**From:** Christopher Ashworth [REDACTED]  
**Sent:** Wednesday, 24 May 2017 12:25 PM  
**To:** Pilar Aberasturi  
**Cc:** Amy Watson; Brendon Roberts; Bill MacKay  
**Subject:** Section 96 Modifications to the Australian Technology Park, Eveleigh (SSD 7317 MOD 1 and MOD 2)

**NOTICE OF SECTION 96 MODIFICATIONS TO THE AUSTRALIAN TECHNOLOGY PARK, EVELEIGH (SSD 7317 MOD 1 AND MOD 2)**

**OUR REF: R/2015/37/C**

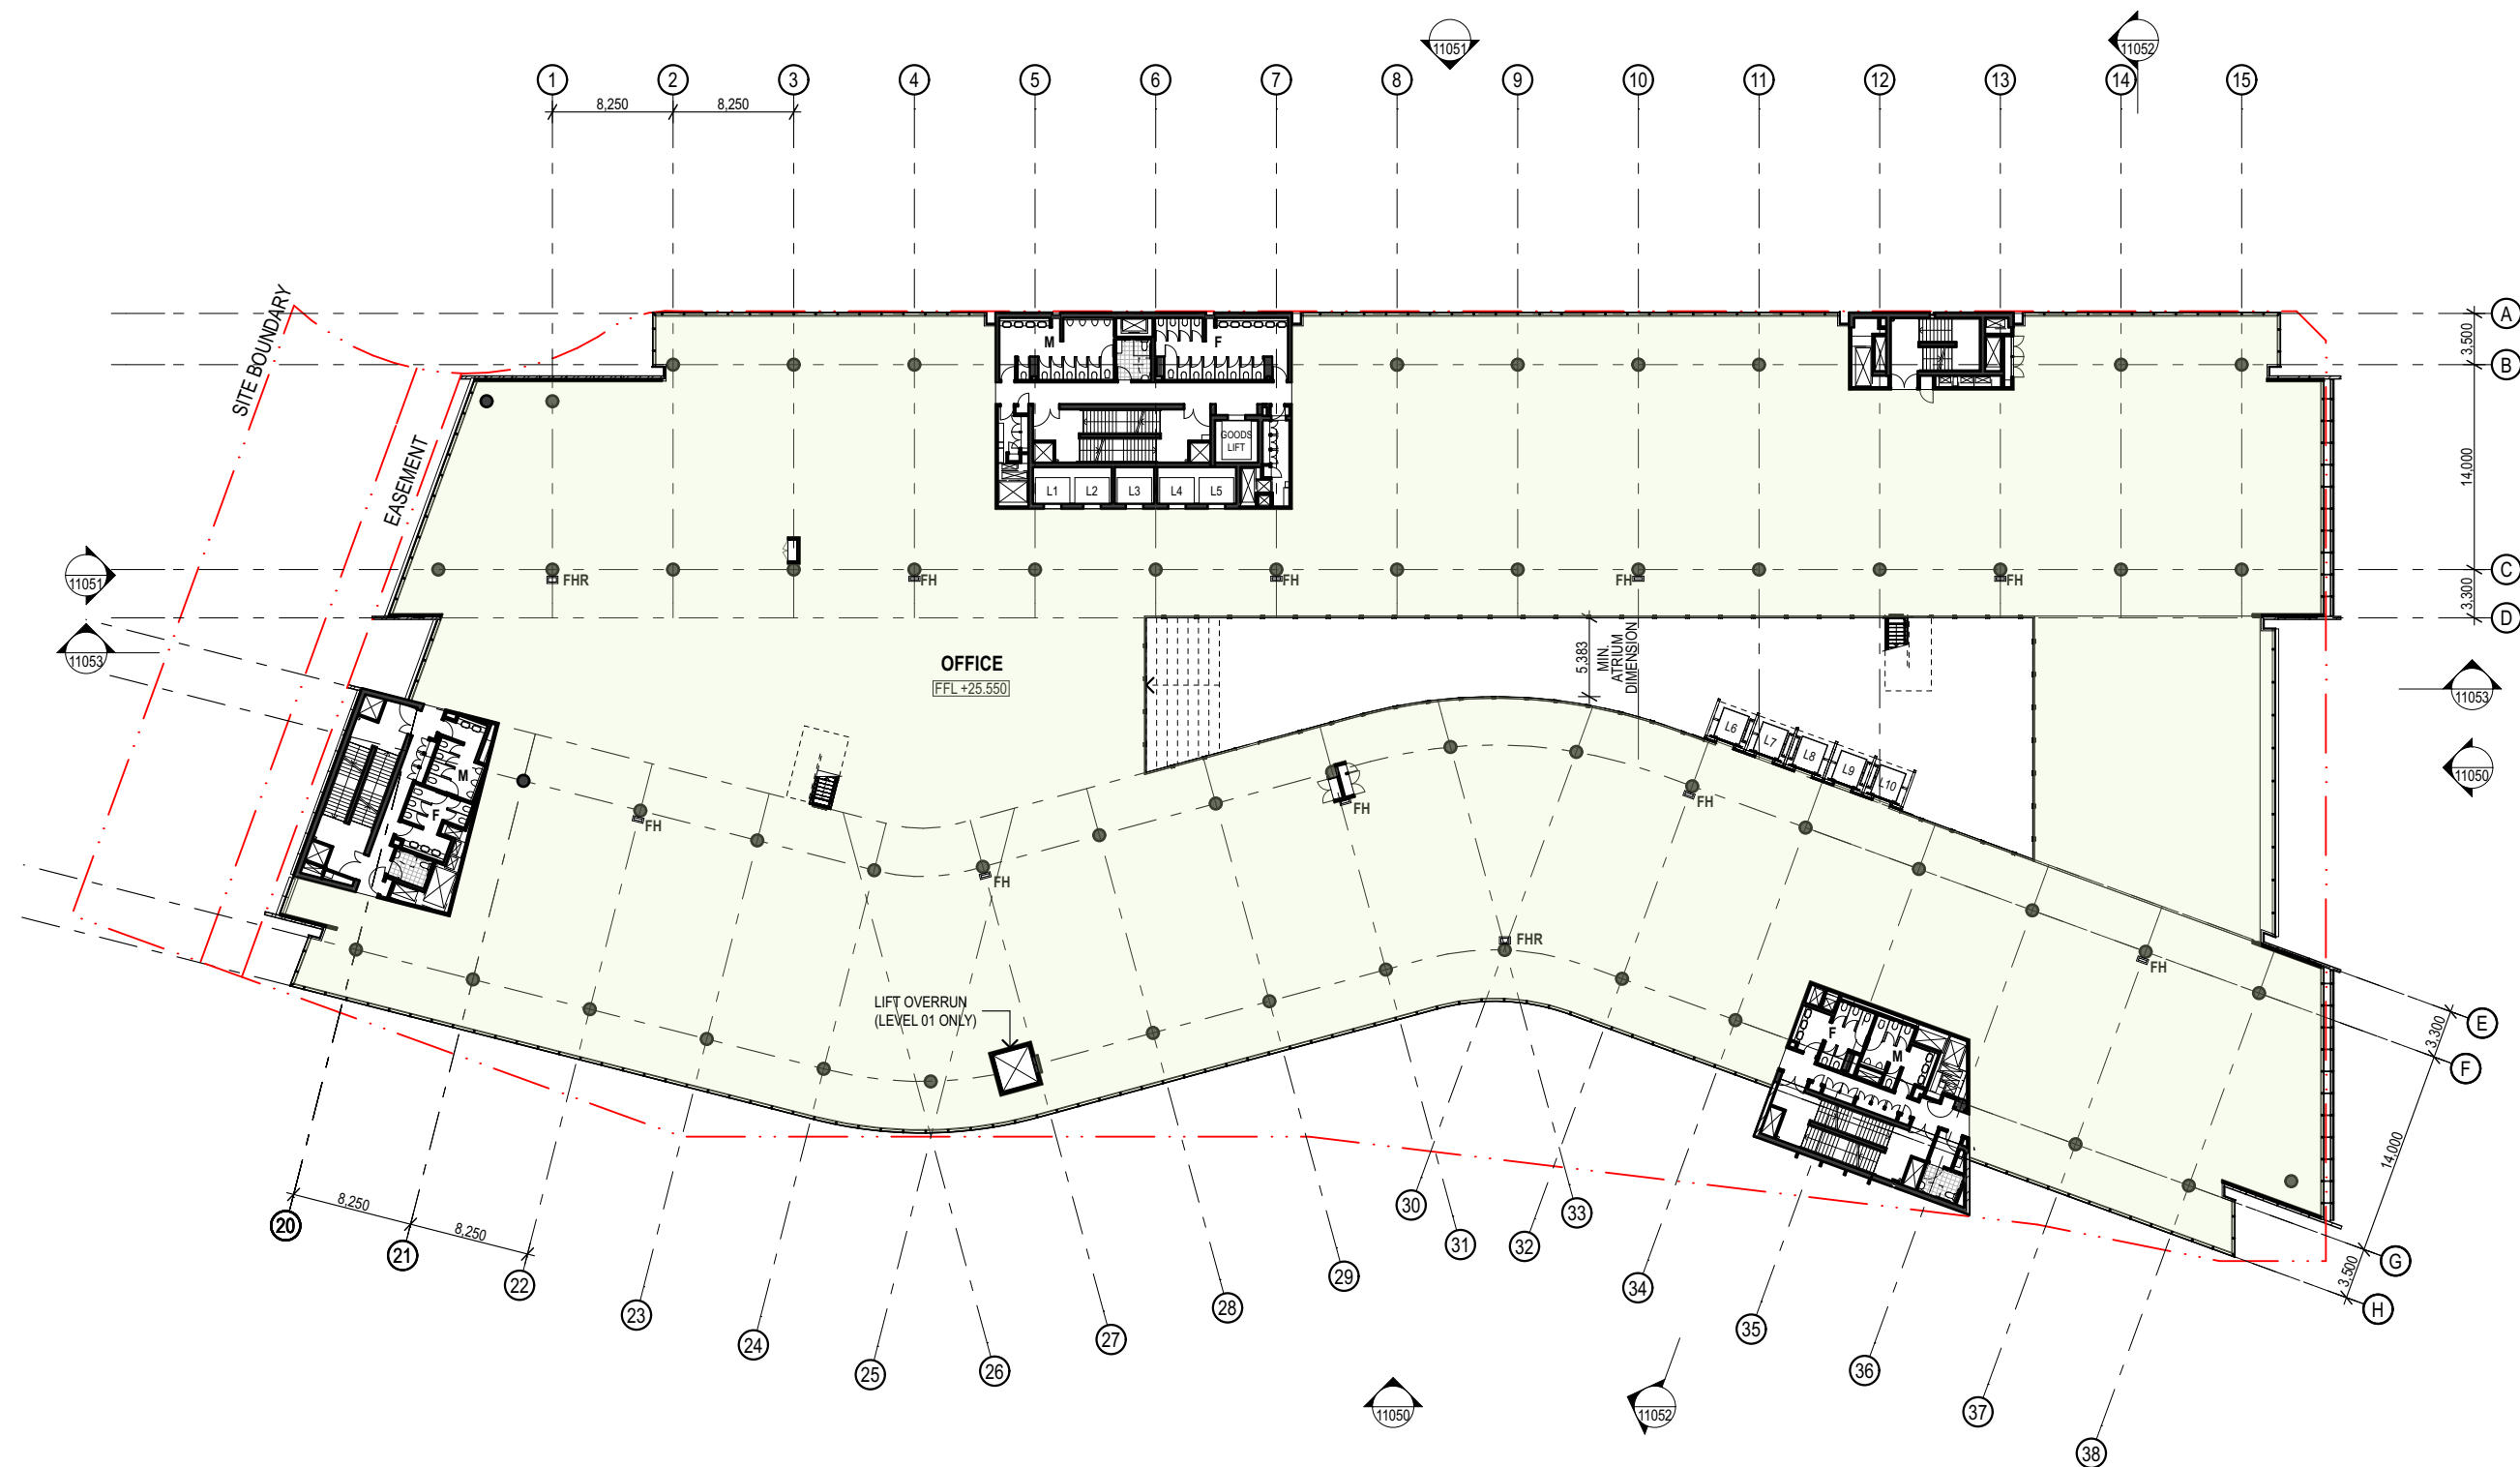
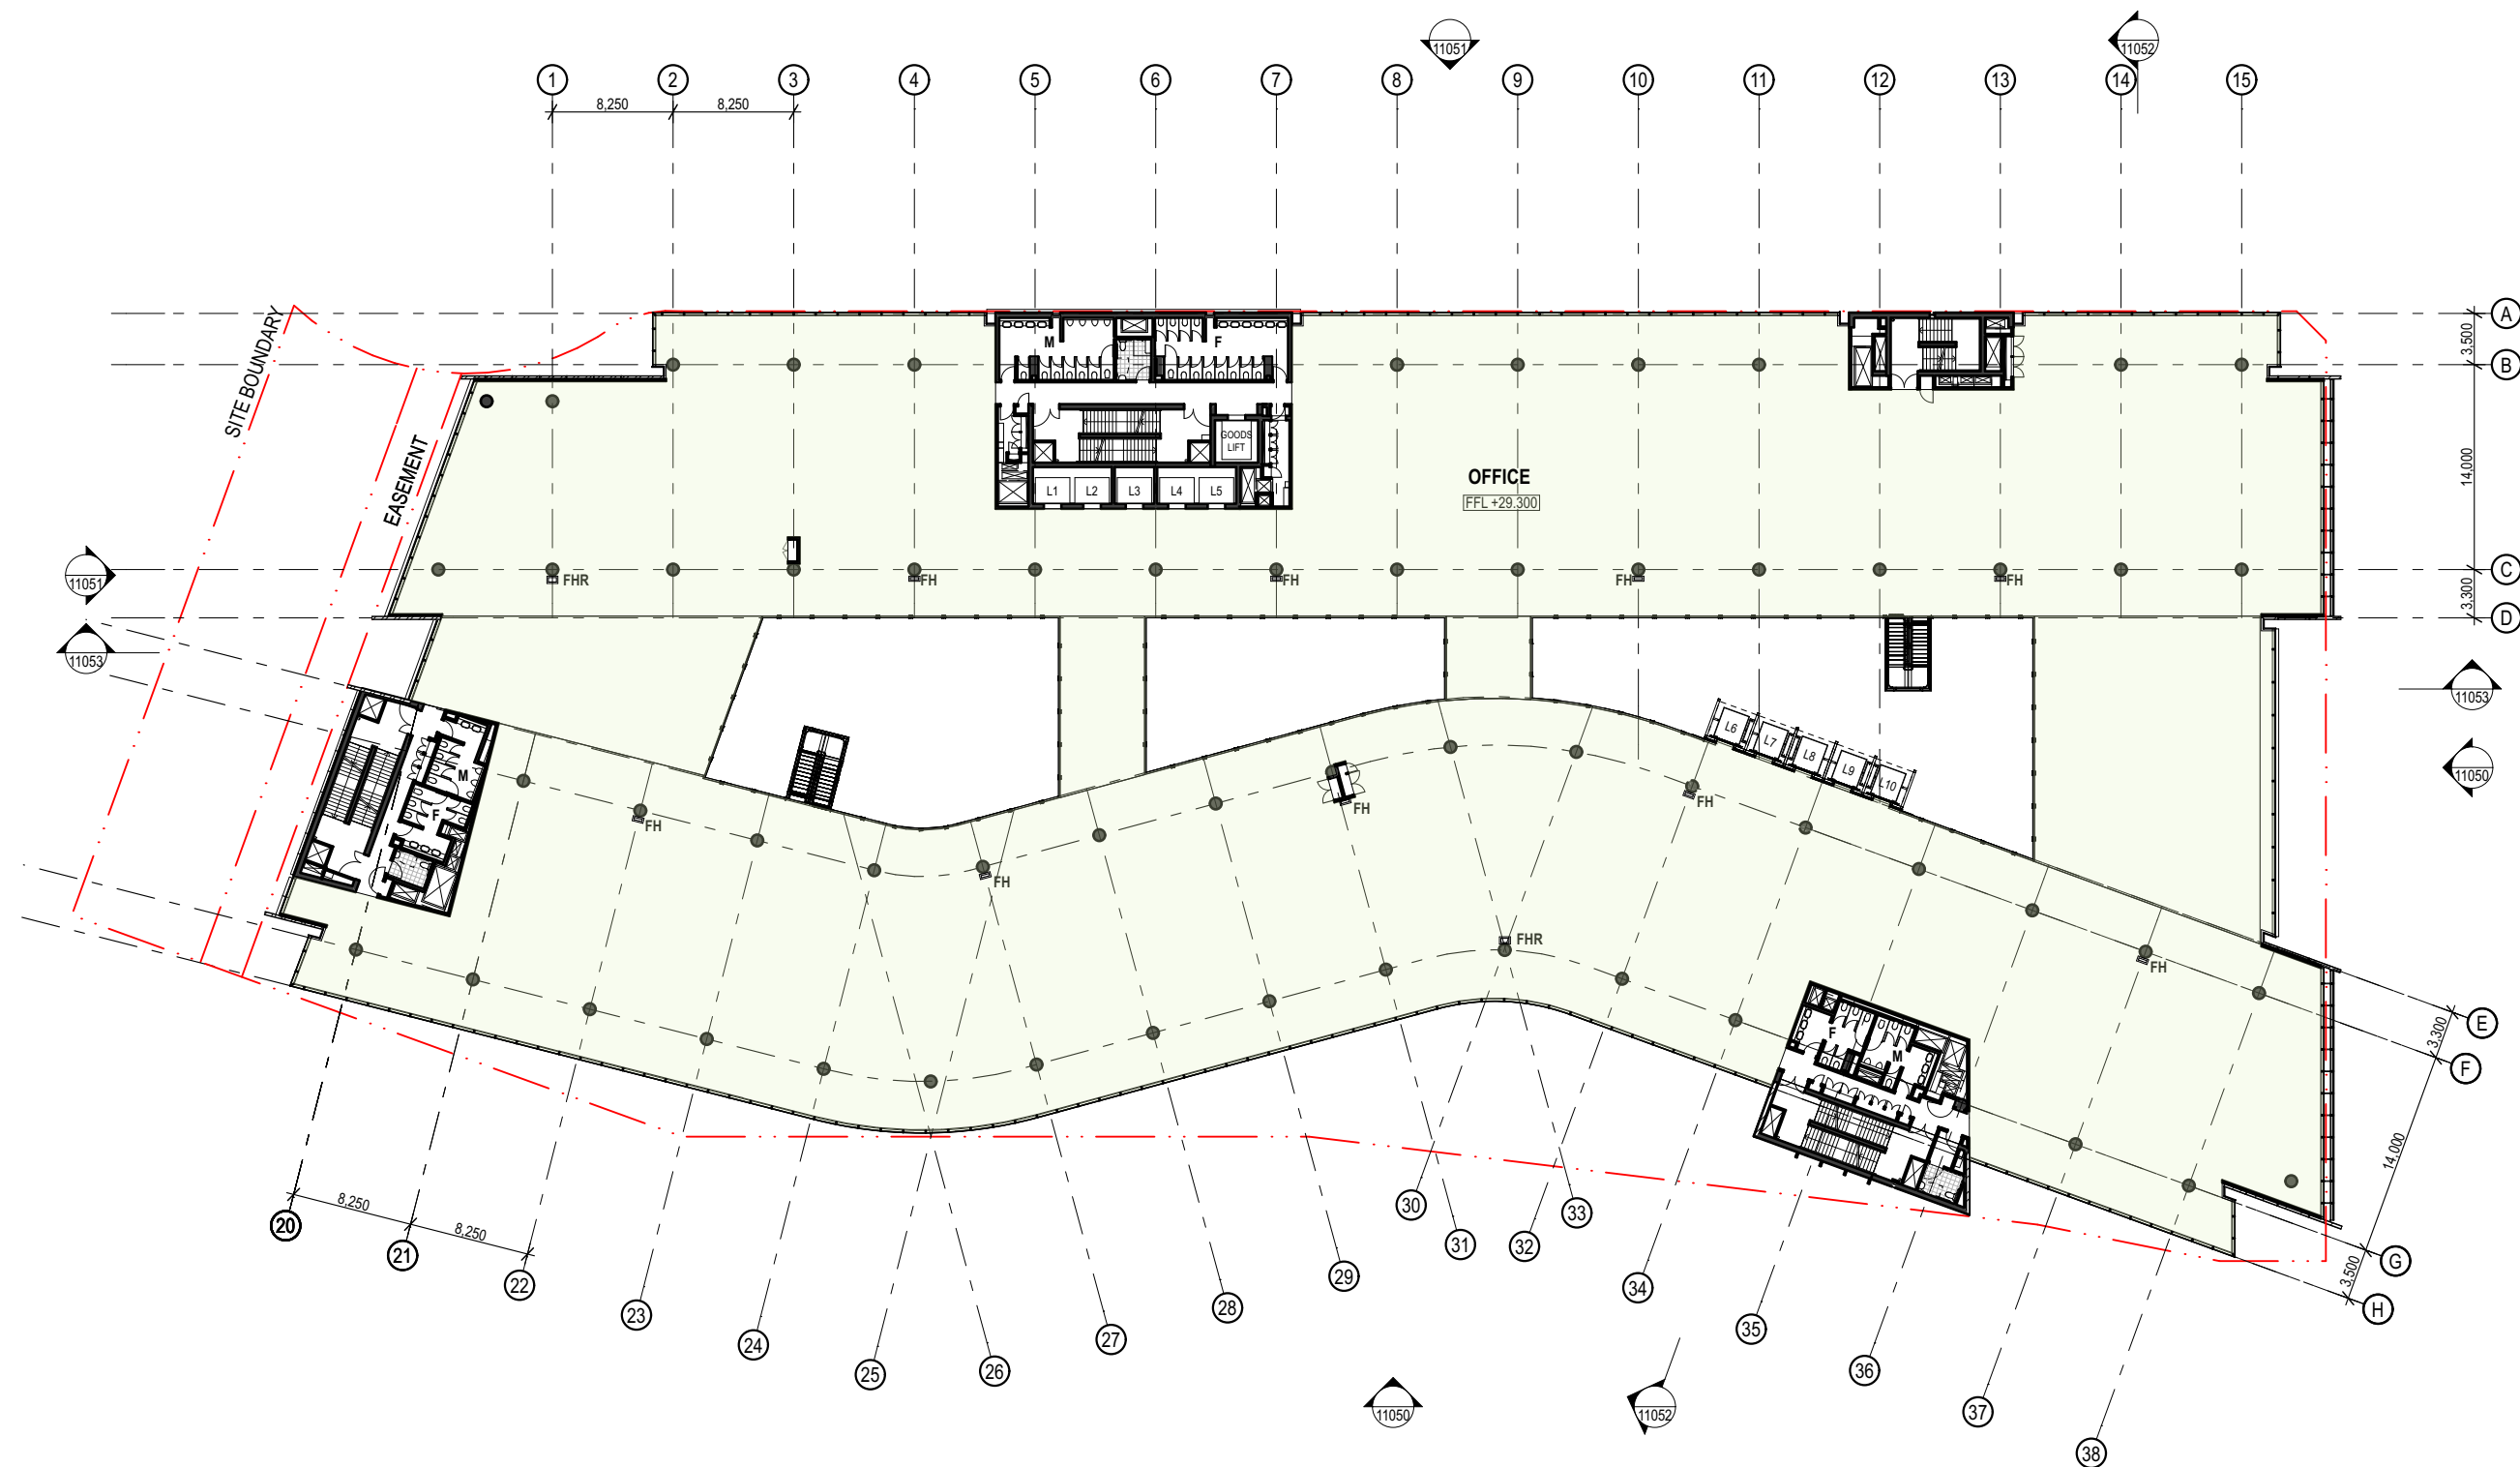
The City also objects to the deletion of secure bicycle parking from the basement areas.
